## **Response to Planning Application**

**Application ref:** A/234/21/DOC

**Description:** Approval of details reserved by condition imposed under hybrid application A/125/13/ relating to Full Condition No 17 - landscaping scheme.

**Location:** Chandlers BMW Worthing Manor Retail Park Rustington BN163FH

drawing no: STORE18832 30 Rev. A (Sheet 1)

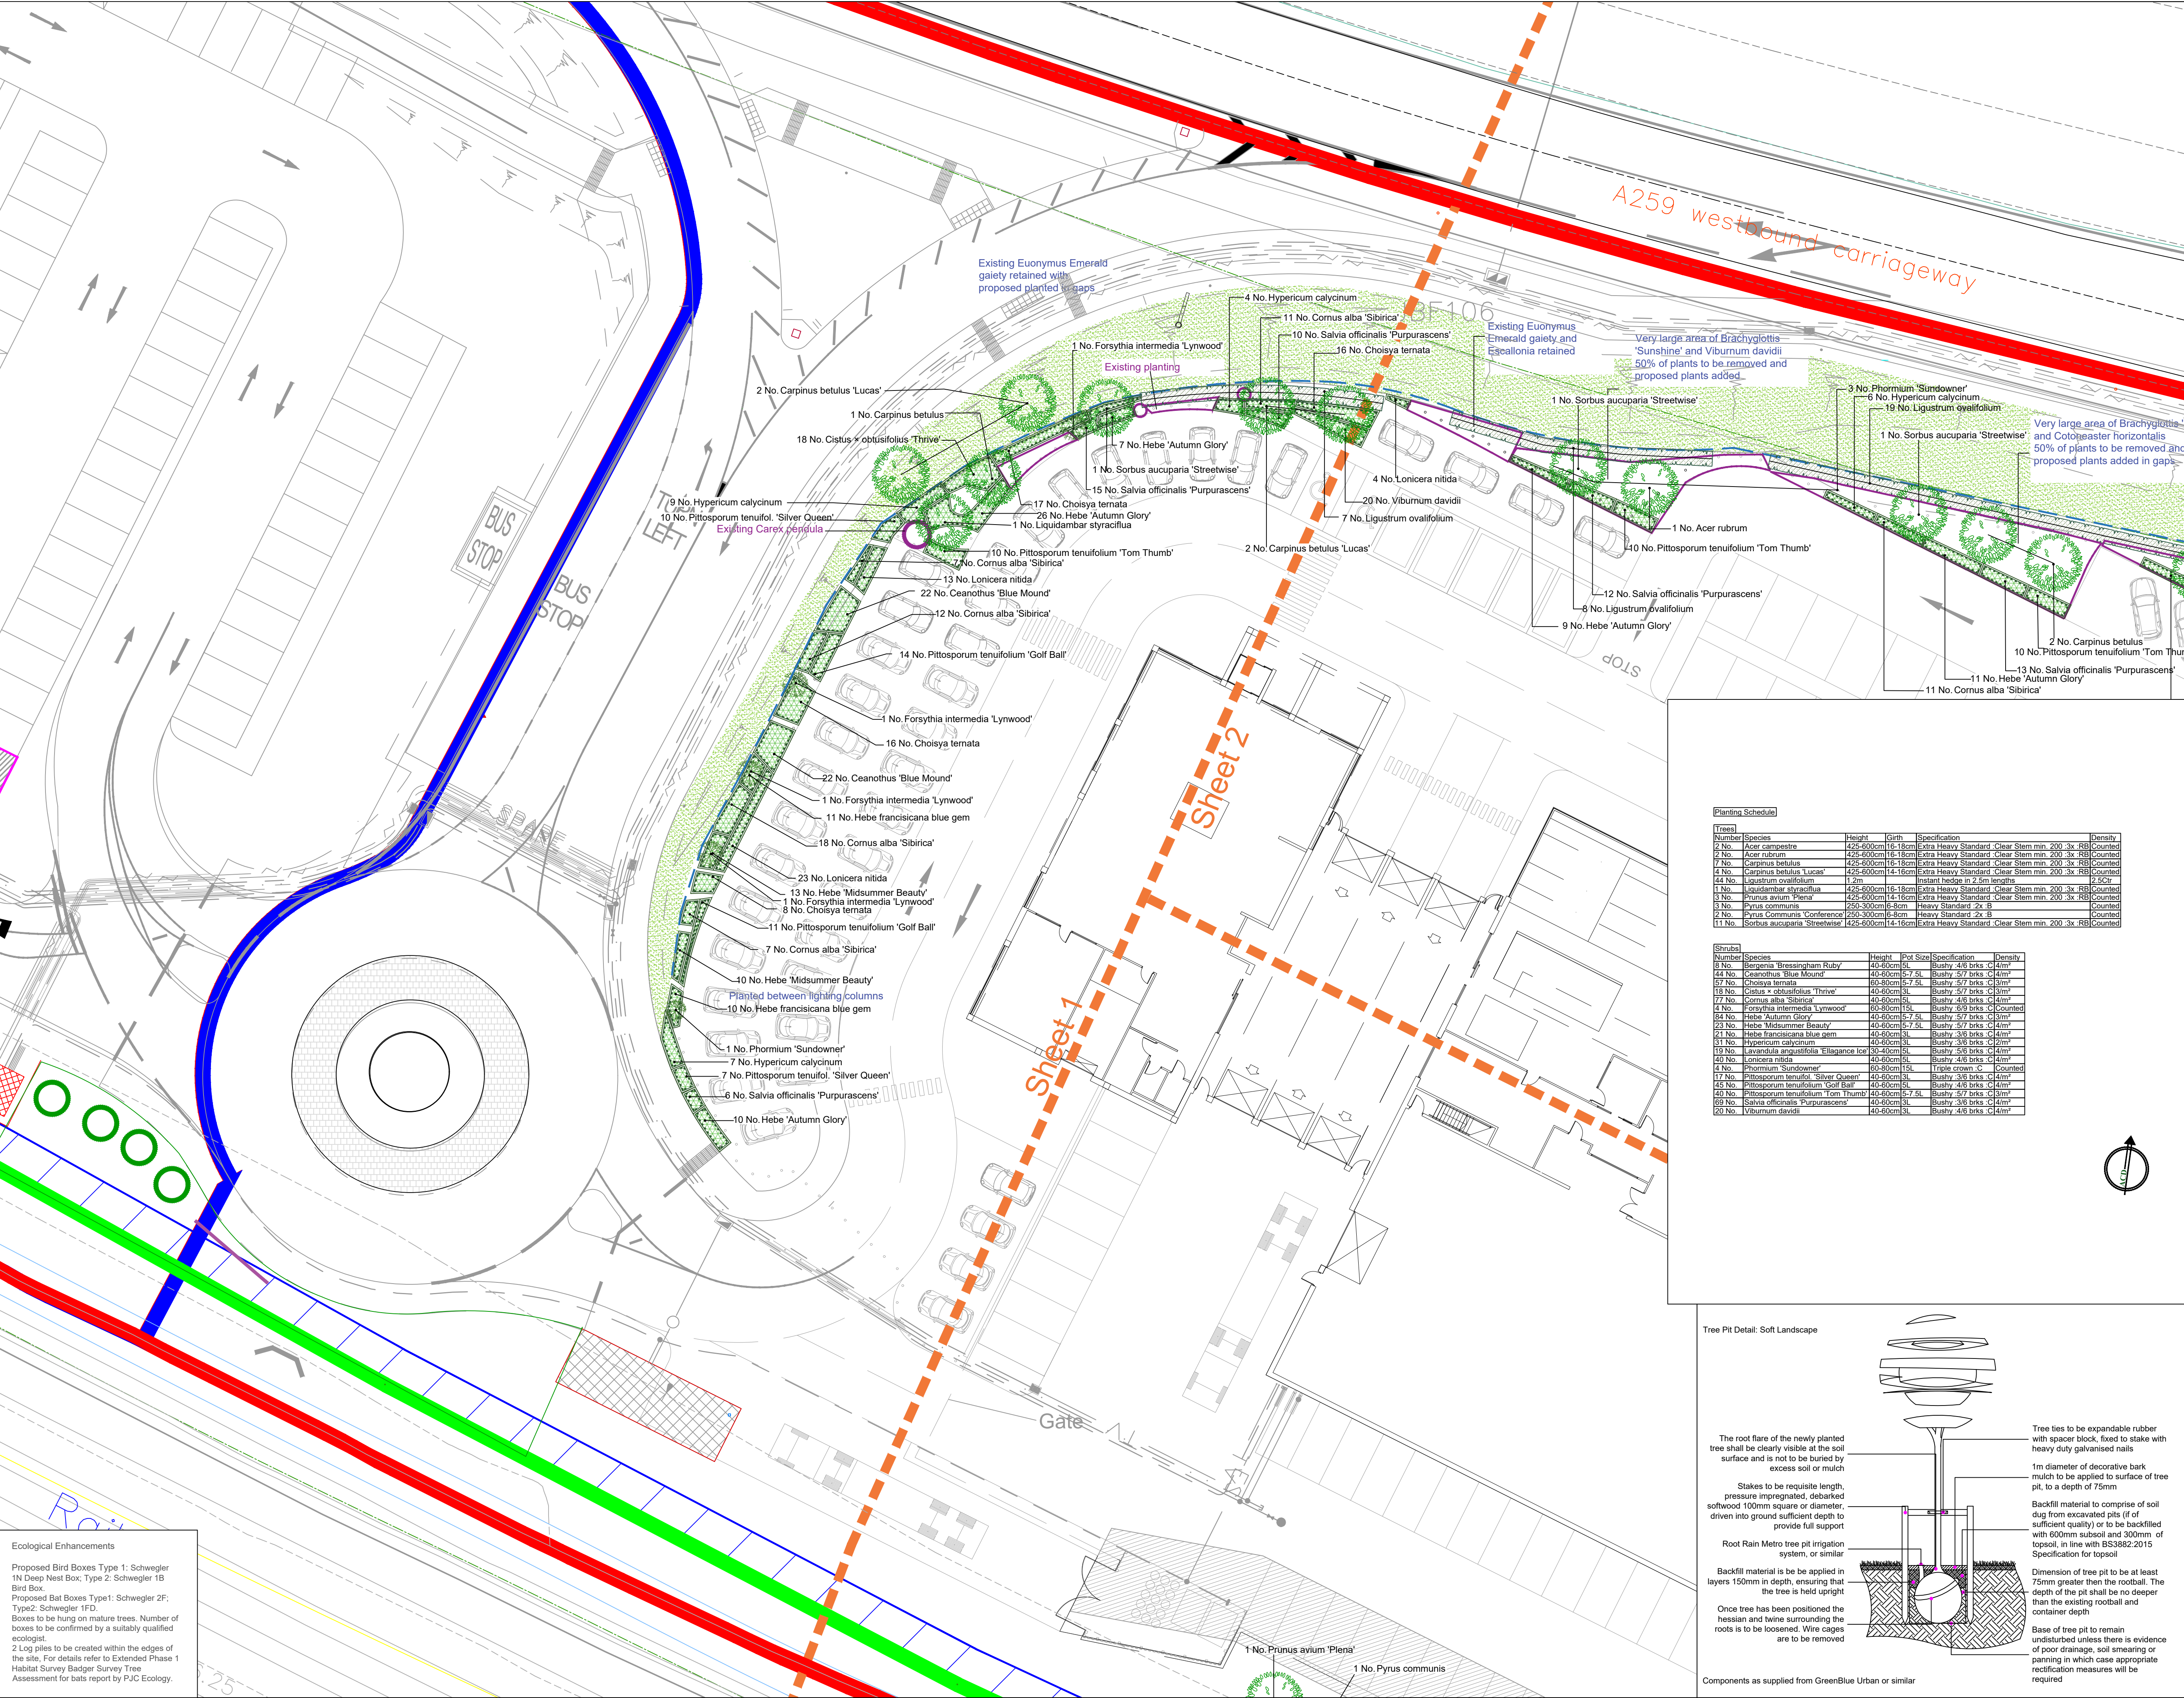
Landscape Re-Planting Dwg No STORE18832 30 Sheet 1 Rev A, Re-Planting Dwg No STORE18832 30 Sheet 2 Rev A and Re-Planting Dwg No STORE18832 30 Sheet 3 Rev A has proposed a suitable landscape scheme with now includes an enhanced shrub planting proposal and a good selection of mixed native and ornamental trees to the building.

The proposed landscape scheme now proposes the removal of some of the mono culture planting blocks and the incorporation of a planting scheme providing a broader shrub selection of varied species and heights. The proposed tree planting proposals are now adequate in quantity, location and specified size and now address the proposed outline scheme previously submitted addressing mitigation for trees removed and the screening requirement in this section of the development parcel. The incorporation of 35no new trees of considered height (inc. 14-16cm girth and 16-18cm girth) will be a welcome addition to this site adding biodiversity habitat opportunity in this location and will provide valuable softening to the building whilst still affording views into the site and will only add to the aesthetics as they establish.

44no Ligustrum ovalifolium for this frontage area, whilst not beneficial from a screening point of view will provide a green backdrop to the adjacent planting and hardstanding areas.

The previous application A/157/21/DOC indicated minimal and inadequate tree planting (6no std Birch 10-12cm) also to the rear of the building this has now been addressed under this application A/234/21/DOC proposing mixed tree planting also to the rear southern side of the building as required.

These revised proposals are recommended to be implemented within the planting season October-March inc and receive suitable maintenance to ensure their establishment. Any trees and shrubs within these proposals which fail to establish and thrive within 12 months of planting must be replaced on a like for like basis with trees and shrubs of the same species at the specified height
